**HAL OWEN & ASSOCIATES, P.C.**

20 October, 2004

Reference: Preliminary Soil Investigation  
Tract 2 - 2.42 Acres

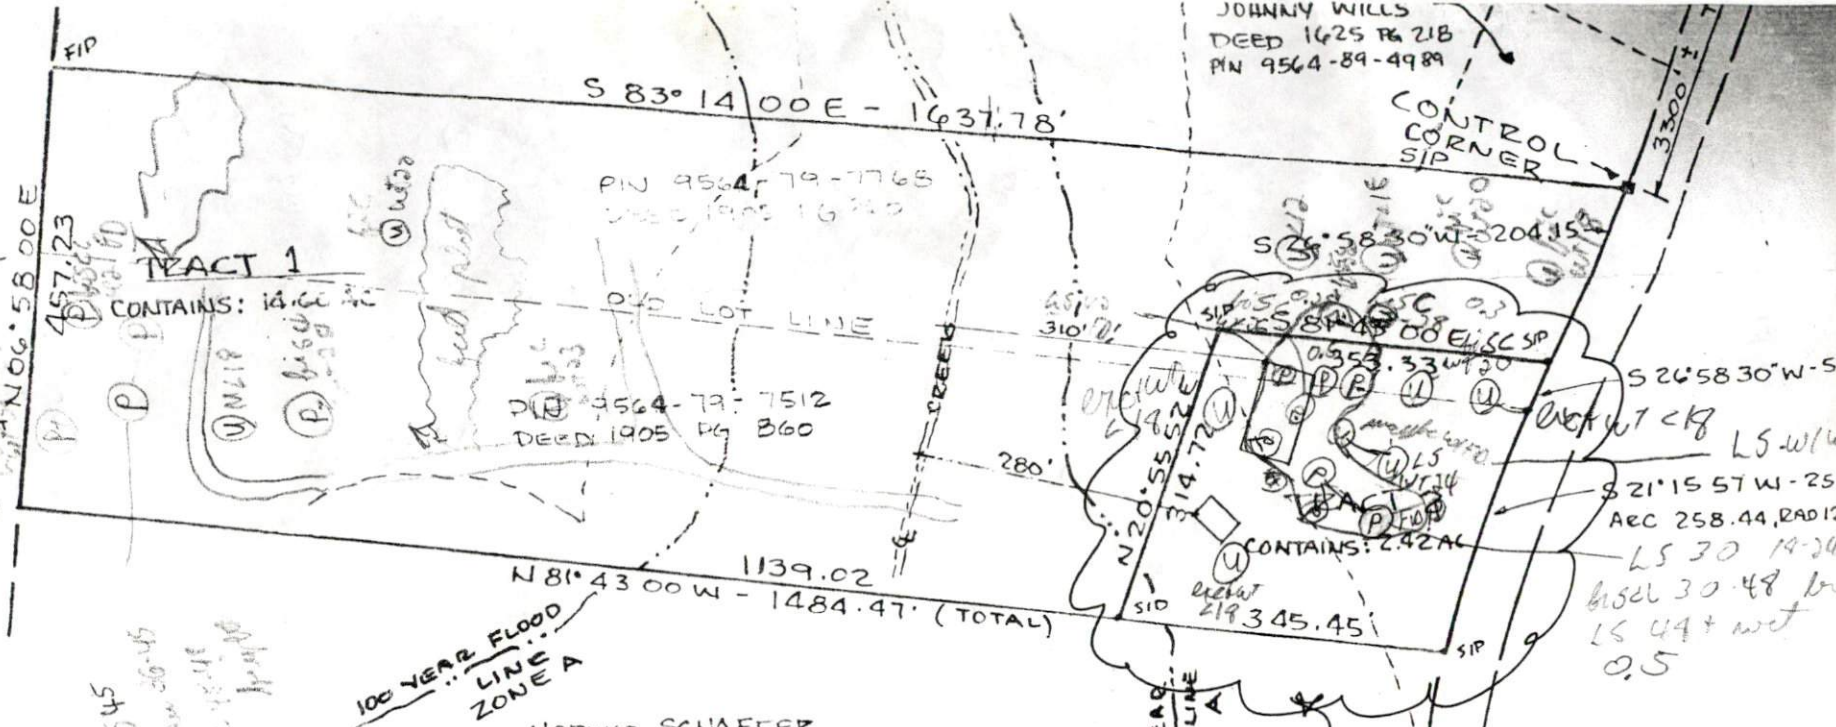
The amount of usable soil at the site is very limited and the proposed house site occupies a portion of the usable soil area. It may be necessary to site the house and all other entities (driveway, storage building, etc.) outside of the usable soils in order to provide the septic needs of the lot. In addition the usable soils are dominantly located at higher elevations than the proposed house site and a pump will be required. It is recommended that you relocate the house to the right central portion of the lot in the unsuitable soil area at the top of the hill. This will allow the potential to obtain a permit for a gravity driven system and free up the usable soils that are under the presently proposed house site. The soil investigation noted evidence of lateral water movement throughout much of the usable soil area, which can adversely affect the

function of a septic system. It will likely be required, and is highly recommended, that a curtain drain be installed above the septic system to address this problem. This curtain drain can likely function as a foundation drain if the house is moved to the top of the hill.
